CITY OF ALBUQUERQUE

**RE: Ladera Crossing Self Storage
7901 Ladera Drive NW
Temporary C.O. - Accepted
Engineer's Certification Dated 01/29/19
Engineer's Stamp Date: 02/15/18
Hydrology File: H09D028**

GRADING & DRAINAGE PLAN

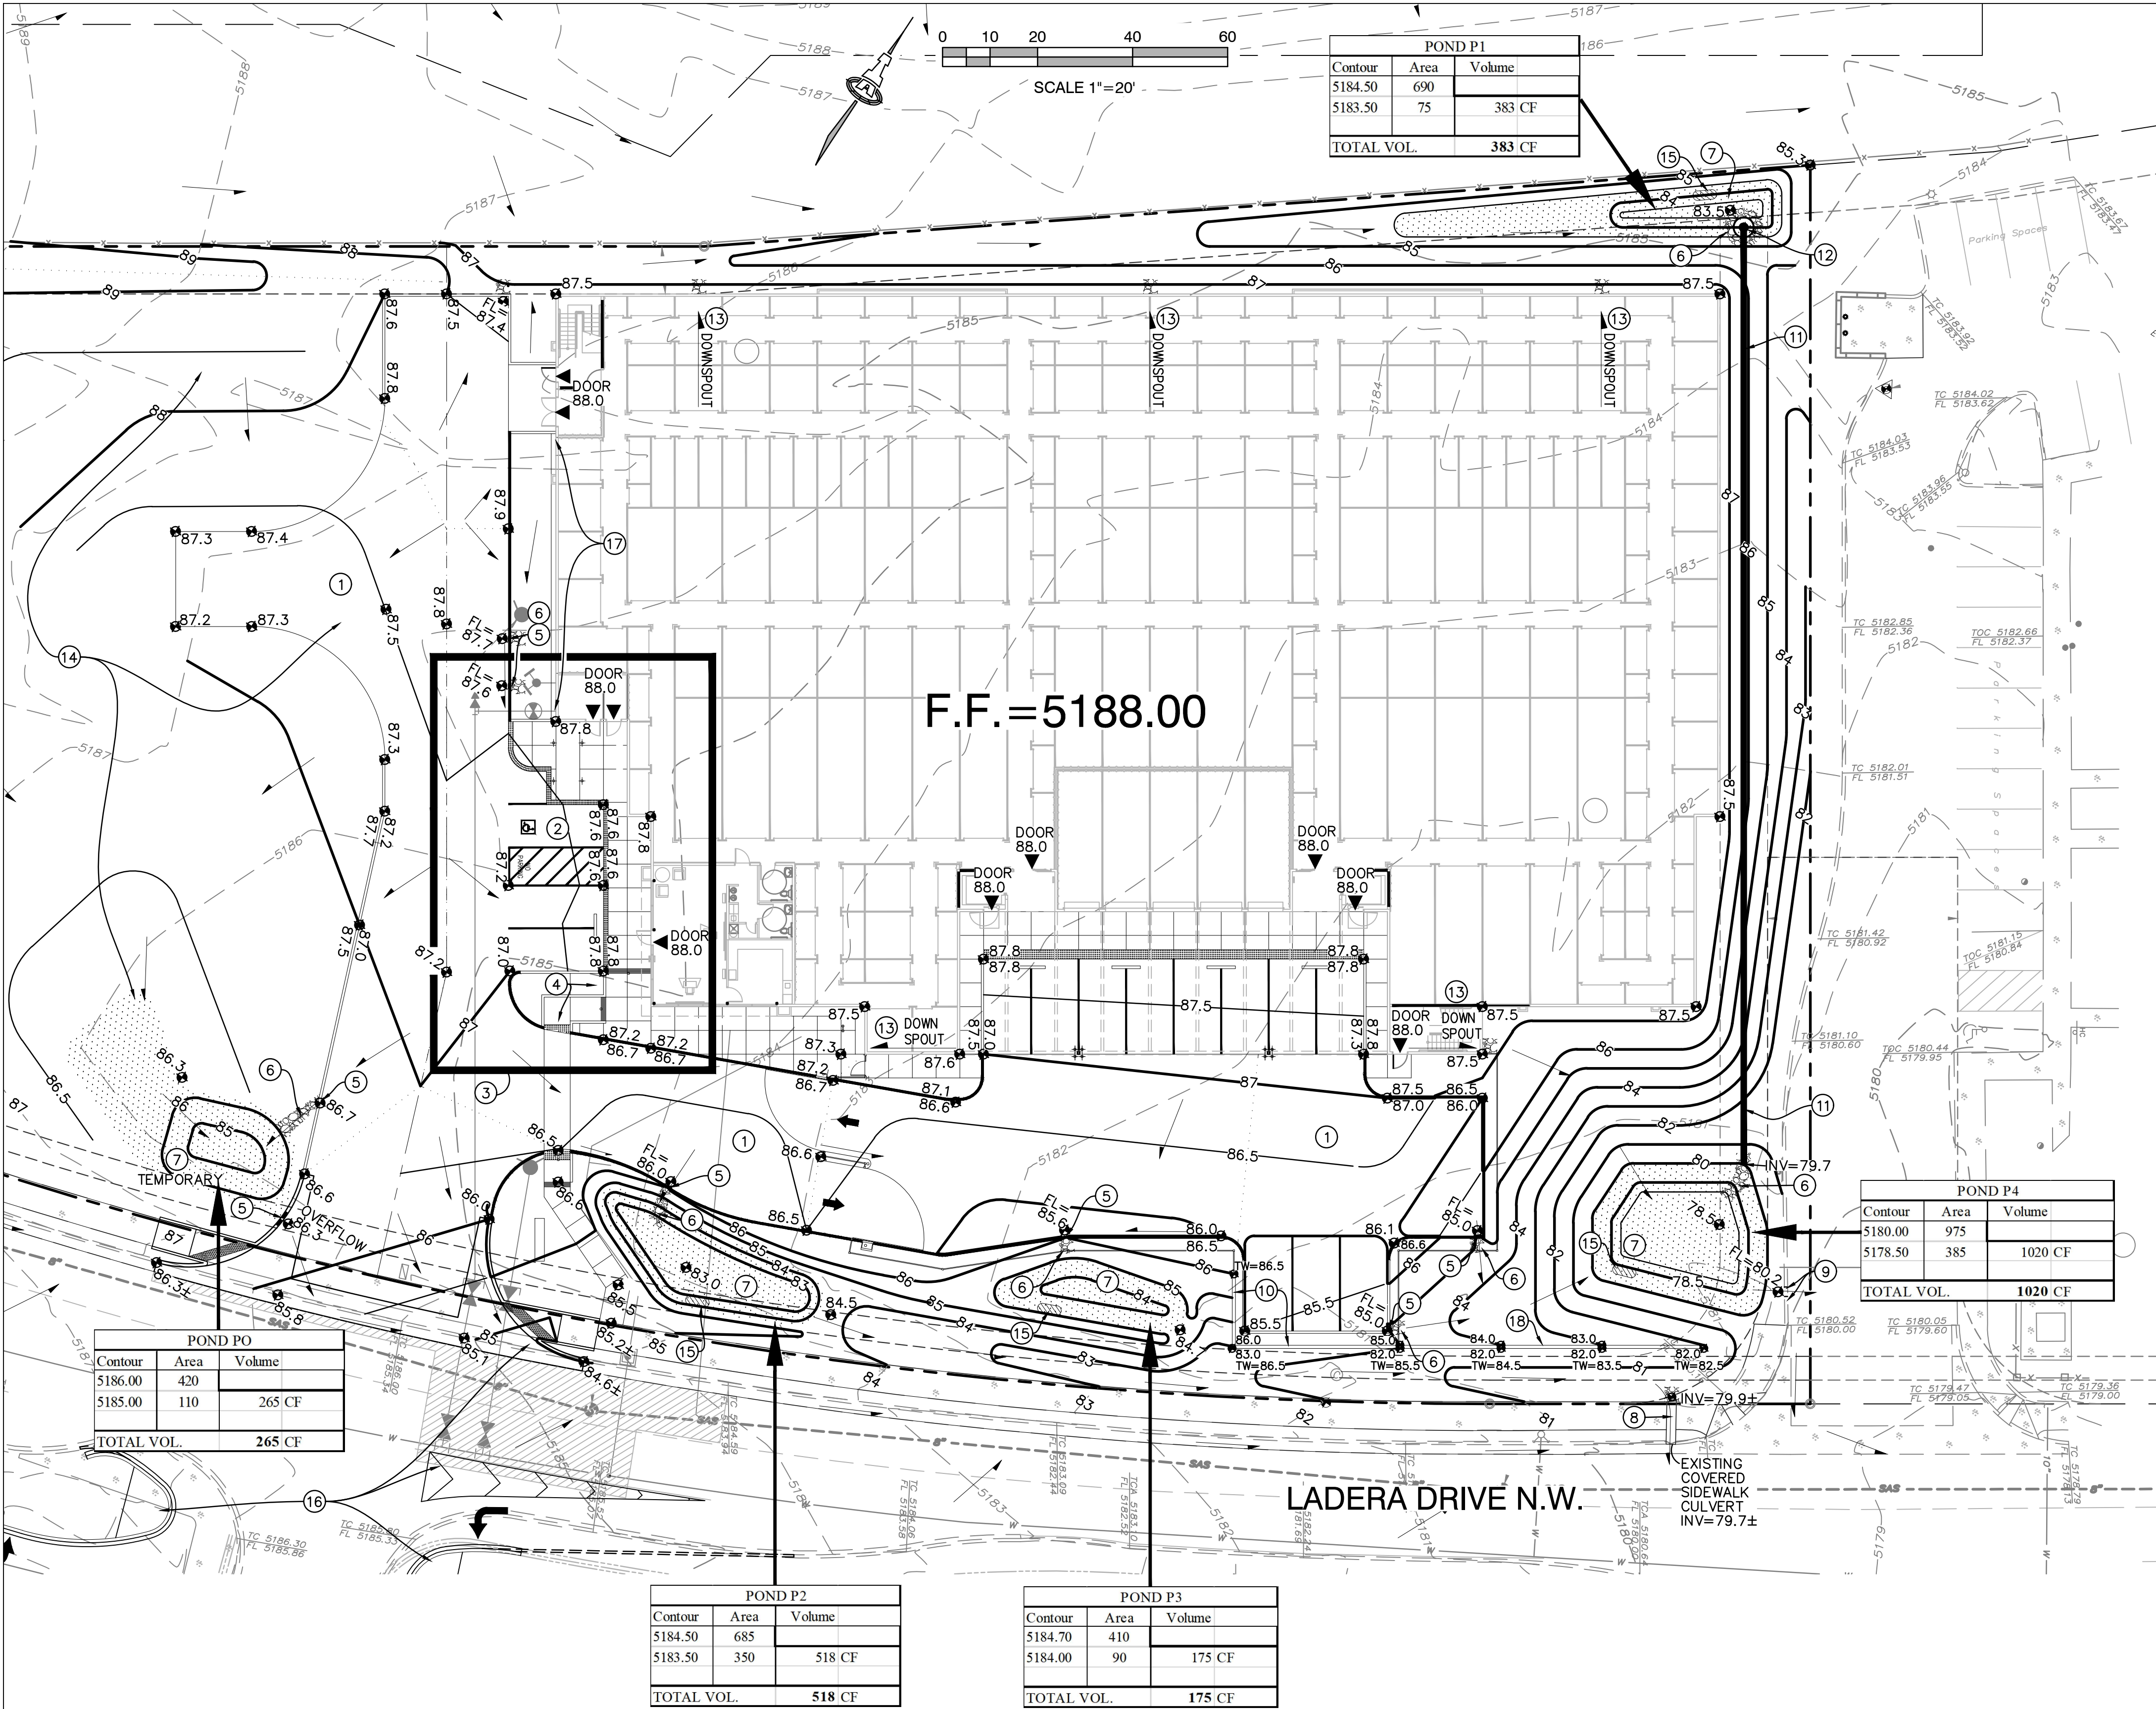
1. Please provide the required off-site temporary pond as noted on the approved Grading and Drainage Plan.
2. Please add a swale from the stormwater quality pond to the sidewalk culvert so overflow drainage can be directed to the culvert. See attached photo.
